Community Consultation

CONSULTATION OVERVIEW

The consultation process sought out community and stakeholder feedback on the proposed design for Block 11. Community feedback was pivotal to the development of the proposed scheme and would underpin the design process leading up to the submission of the State Significant Development Application (SSDA) with the Department of Planning and Environment.

WELLINGTON STREET
SHADOW ANALYSIS JULY 21

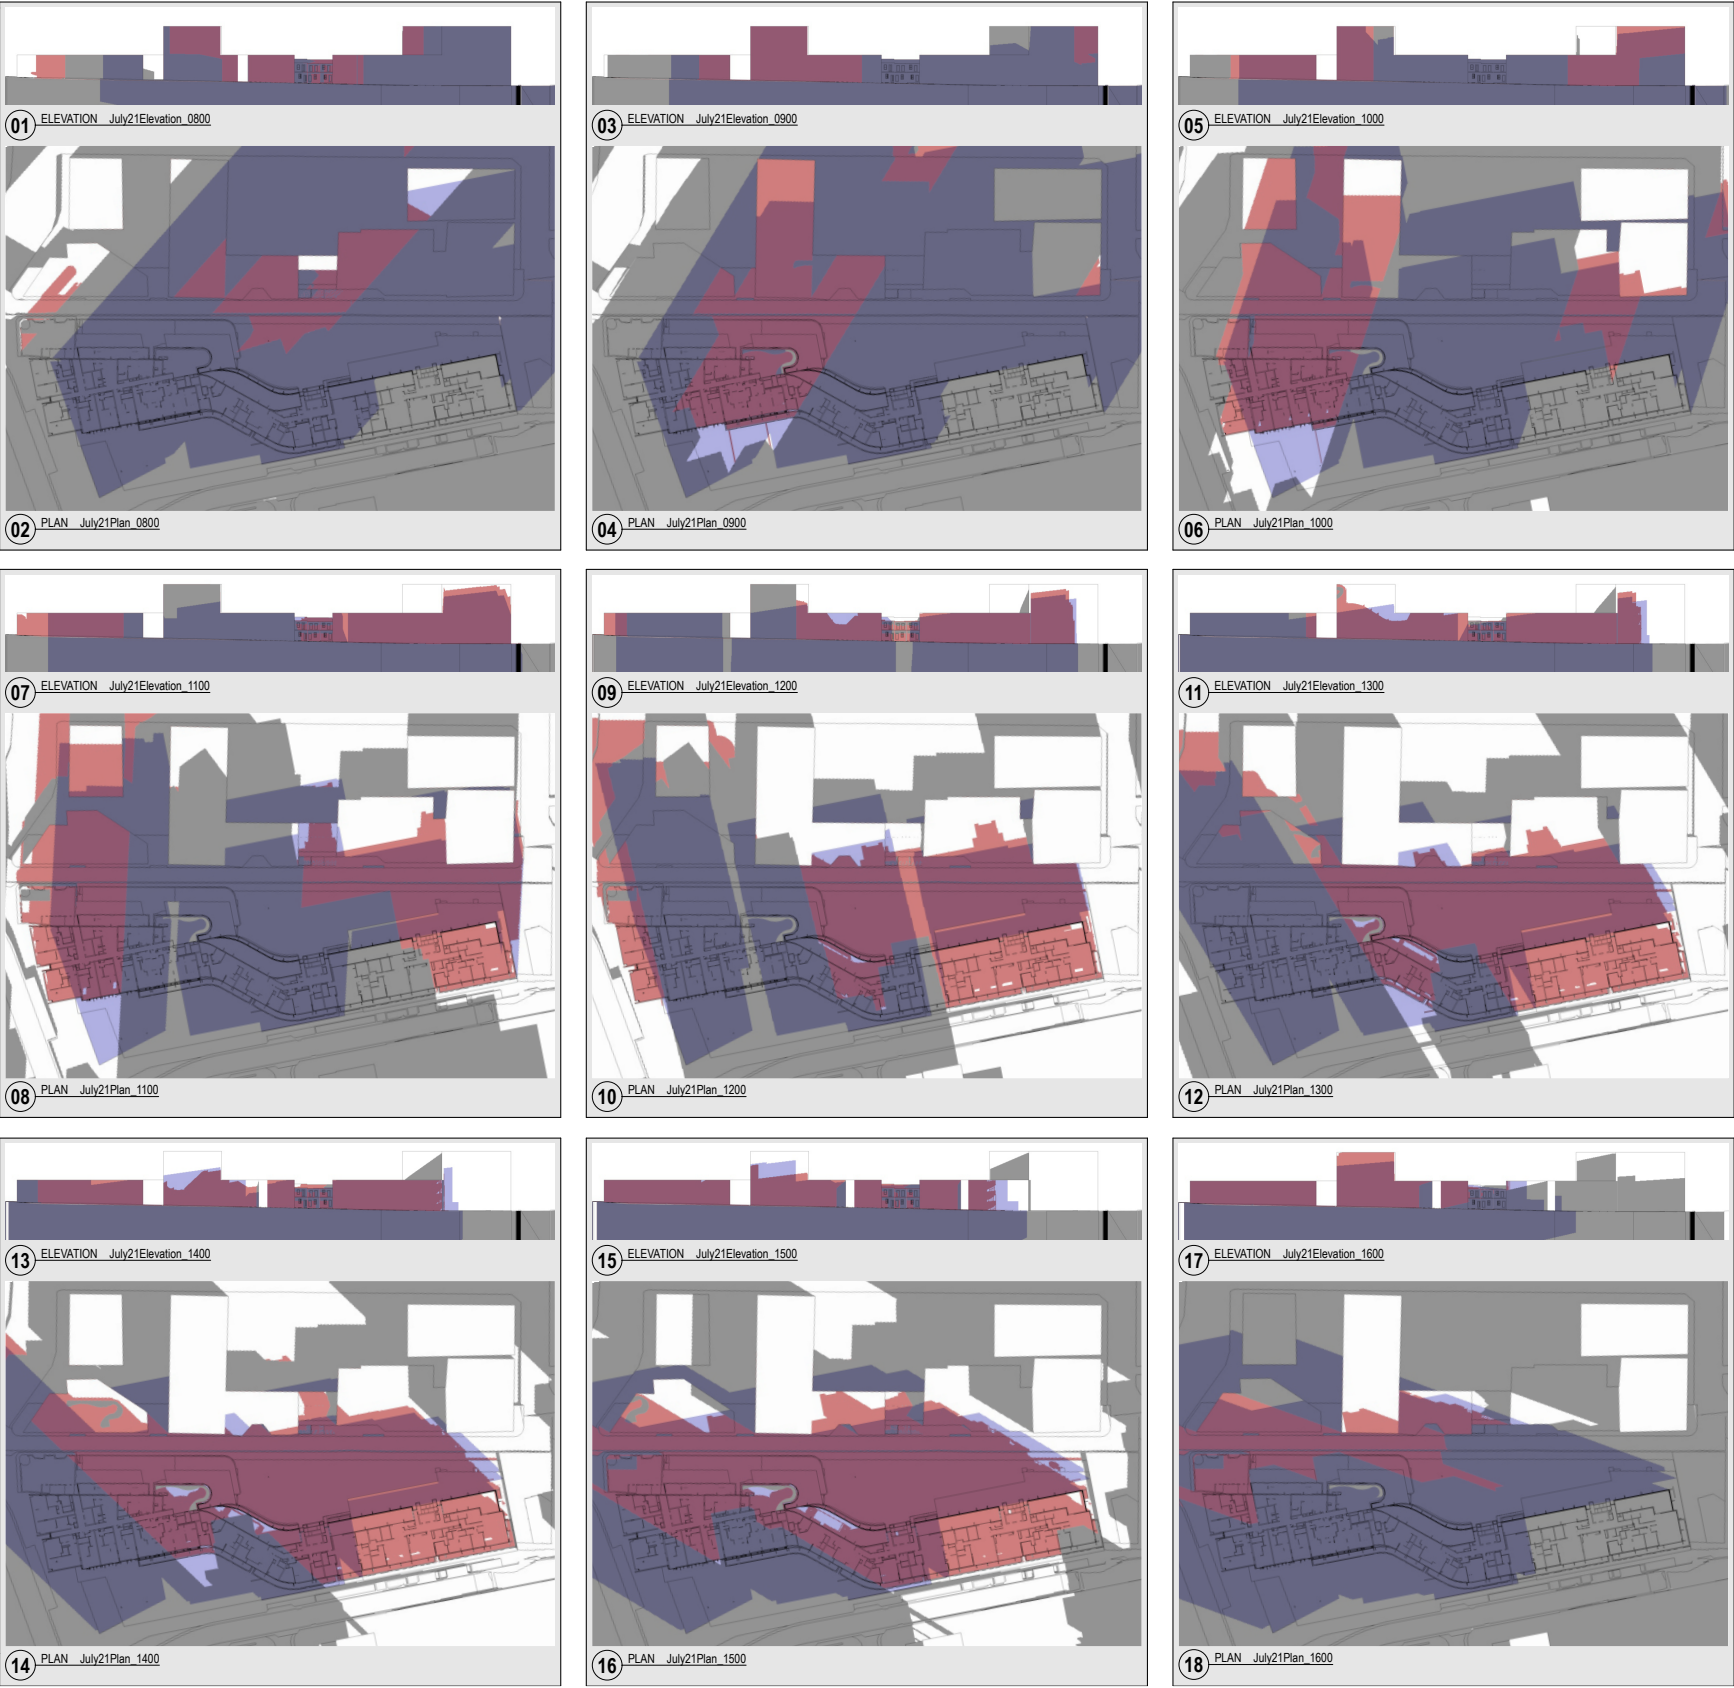
- The impact of over shadowing on residents in Wellington Street and any additional solar loss (when compared to the present situation) that the Block 11 building might create.

- *We presented detailed solar analysis which illustrated the beneficial solar outcome for Wellington Street residents delivered by the Proposed Design in comparison to that achieved by the Approved Concept Plan envelope.*
